**WEST SUSSEX COUNTY COUNCIL
STRATEGIC PLANNING CONSULTATION**

SUBJECT: BE/125/14/DOC

**Application for approval of matters reserved by condition imposed under
BE/73/14/PL relating to condition 6 for a Development Construction
Management Plan.**

Land at Oldlands Farm, Shripney Road, Bognor Regis, PO22 9NN

DRAWING TITLE:
Main Site Access & Logistical Management

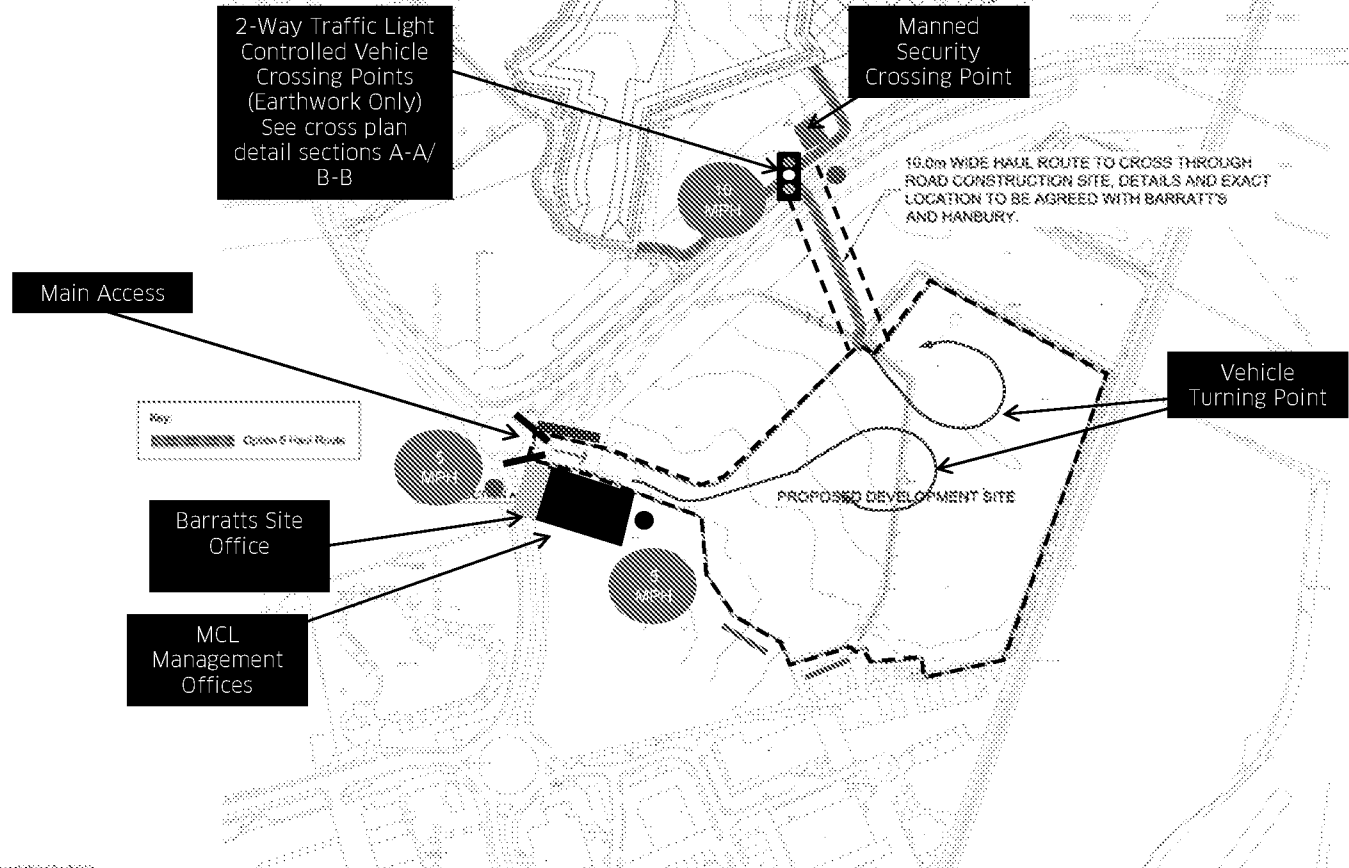
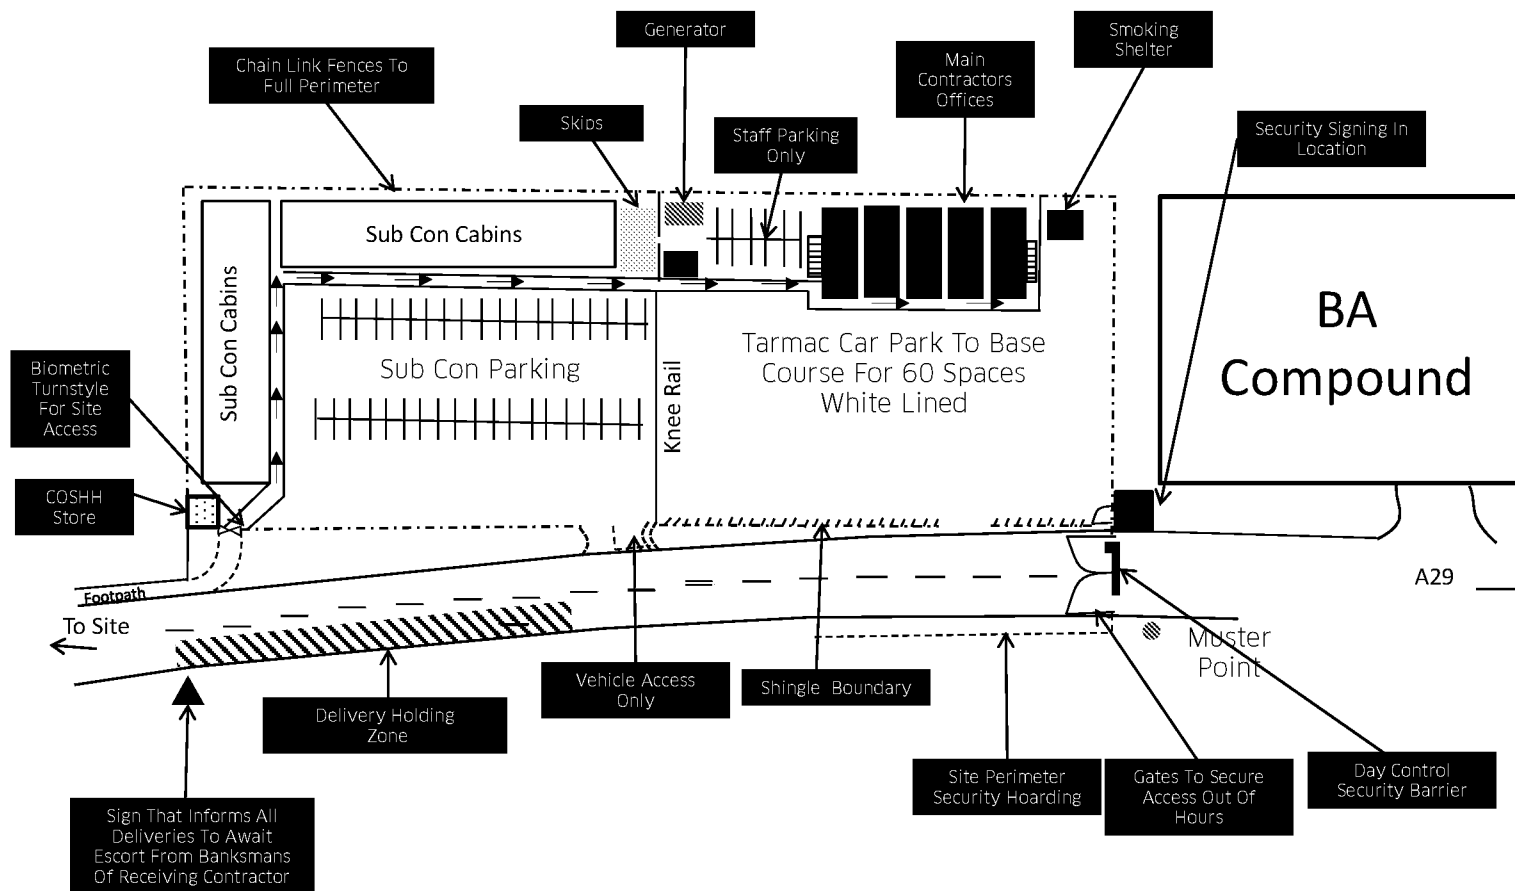
West Sussex County Council (WSSCC), in its capacity as the Local Highway Authority (LHA), has reviewed the Construction Management Plan submitted to discharge condition 6 of BE/73/14. The LHA are generally satisfied with the proposed management plan but seek clarification on the operation of the 'Main Access Gate'. From drawing T1073/005 this would appear to be located adjacent to the highway and, in the event that a large vehicle accesses the site when the gate is closed, could lead to the obstruction of the highway.

The LHA seek clarification as to whether this will remain open during the course of the day, as it is noted that a security hut and a further drop barrier exists along the site access road. If the gate is to be closed during the working day this should be located a distance of 17m from the carriageway to ensure there is sufficient room for a large articulated vehicle to stand clear of the highway whilst waiting for entry to the site without obstructing the flow of traffic on the roundabout.
